City of Portland, Maine - Building or Use Permit Application
 389 Congress Street, 04101 Tel: (207) 874-8703, Fax: (207) 874-8716

Permit No: 07-0250	Issue Date:	CBL: 034 C001001
------------------------------	--------------------	----------------------------

Location of Construction: 49 MARGINAL WAY (63)	Owner Name: BAYSIDE VENTURES LLC	Owner Address: 50 PORTLAND PIER STE 400	Phone:
Business Name: GTE Federal Credit Union	Contractor Name: Sign Solutions	Contractor Address: 55 Bishop St. Portland	Phone 2078788000
Lessee/Buyer's Name	Phone:	Permit Type: Signs - Permanent	Zone:

Past Use: Commercial- Bank	Proposed Use: GTE Federal Credit Union- Install 2 new signs - 22' x 8.5 bldg sign & 12' - 4 3/4 and	Permit Fee: \$242.00	Cost of Work: \$242.00	CEO District: 1
Proposed Project Description: GTE Federal Credit Union- Install 2 new signs - 22' x 8.5 bldg sign & 12' -4 3/4 and		FIRE DEPT: <input type="checkbox"/> Approved <input type="checkbox"/> Denied	INSPECTION: Use Group: Type	
		Signature:	Signature:	
PEDESTRIAN ACTIVITIES DISTRICT (P.A.D.)				
Action <input type="checkbox"/> Approved <input type="checkbox"/> Approved w/Condition <input type="checkbox"/> Denied				
Signature: Dat

12'-4 3/4"

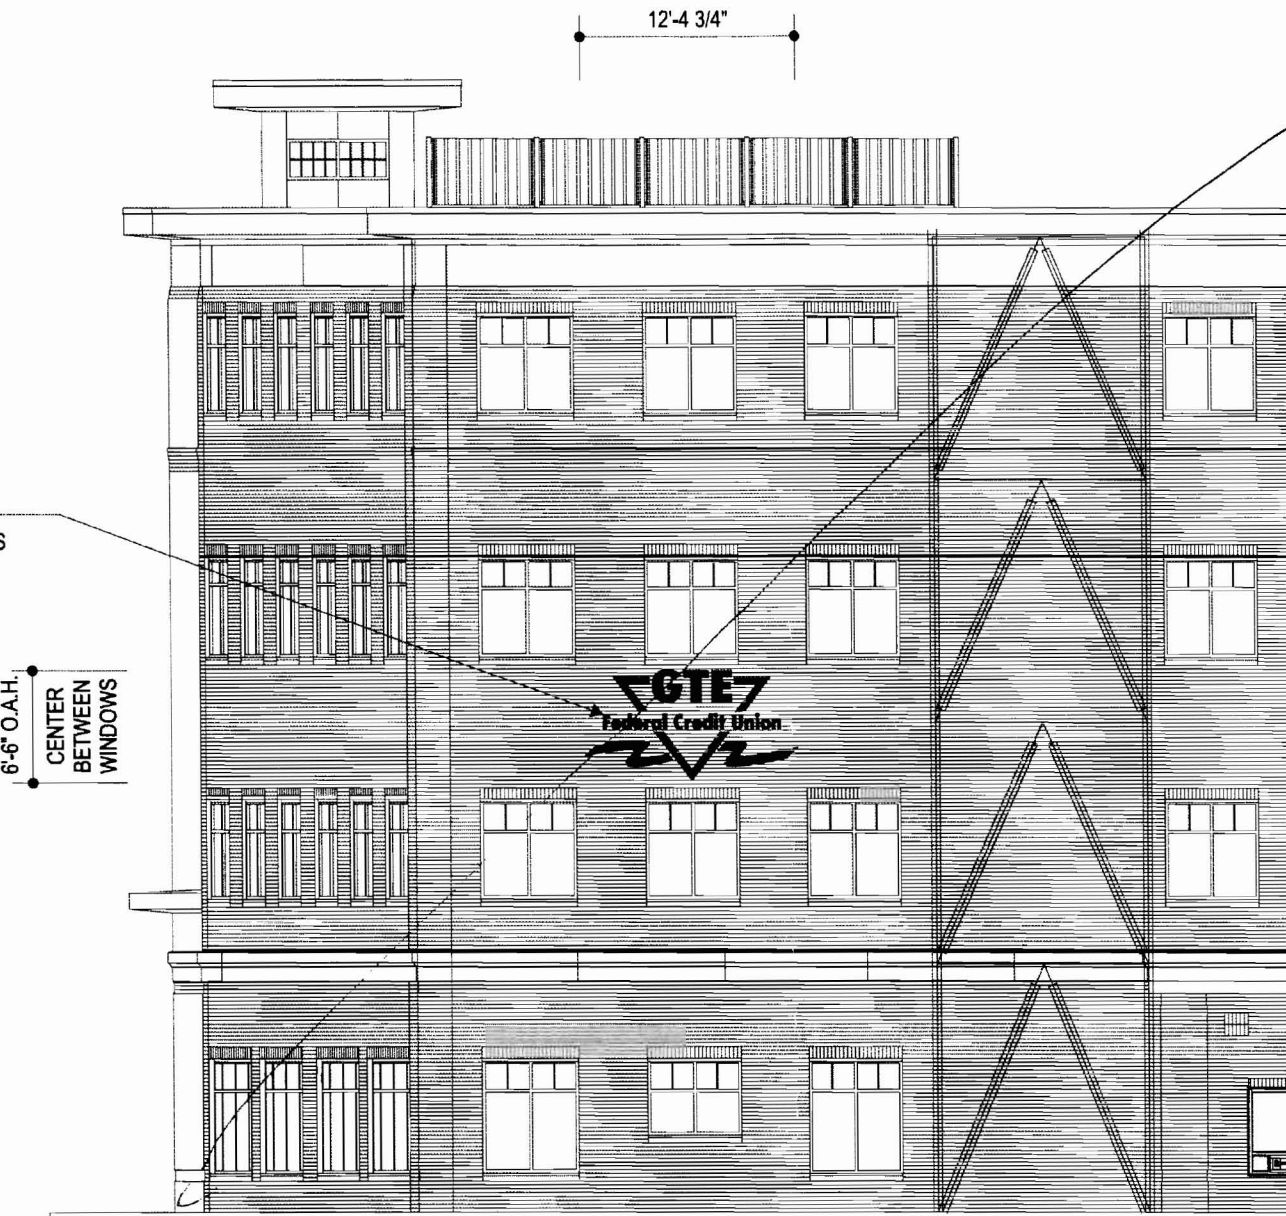
Dept: Zoning	Status: Approved with Conditions	Reviewer: Ann Machado	Approval Date: 03/15/2007
Note: GTE Federal Credit Union is located in suite 1 on the first floor of the building. Section 14-369.5, Table 2.8 of the ordinance only allows one sign for an individual ground floor tenant unless they front on more than one street. GTE Federal Credit Union only fronts on Marginal Way so they can only have one sign. Stephen Foster of GTE Federal Credit Union would like to permit the 38 sf sign on Marginal Way and is appealing to the Planning to have the second sign. Wrote denial letter for second sign 3/15/07. 1) Permit is for 22' x 1'8.5" sign only. 12'3.75" x 6.5' sign is denied.			Ok to Issue: <input checked="" type="checkbox"/>
Dept: Building	Status: Pending	Reviewer: Residential Plan Revie	Approval Date:
Note:			Ok to Issue: <input type="checkbox"/>

Comments:
3/14/2007-amachado: Left message with David Simmons at Allen Industries and Stephen Foster of GTE Federal Credit Union to find out what floor it is located on and what the suite number is.
3/14/2007-amachado: Spoke to Stephen Foster. The credit union is located in Suite 1 on the ground floor.
3/15/2007-amachado: Left message for Stephen Foster. Told him that the credit union can only have one sign according to section 14-369.5, Table 2.8. He needs to let me know which sign they want. Also spoke to David Simmons and Bill Mahl (sign solutions) and told them the same thing.
3/15/2007-amachado: Spoke to Stephen Foster. He would like to permit the 38 sf sign on Marginal Way and appeal the denial of the second sign to the planning authority. See denial laetter dated 3'15/07.
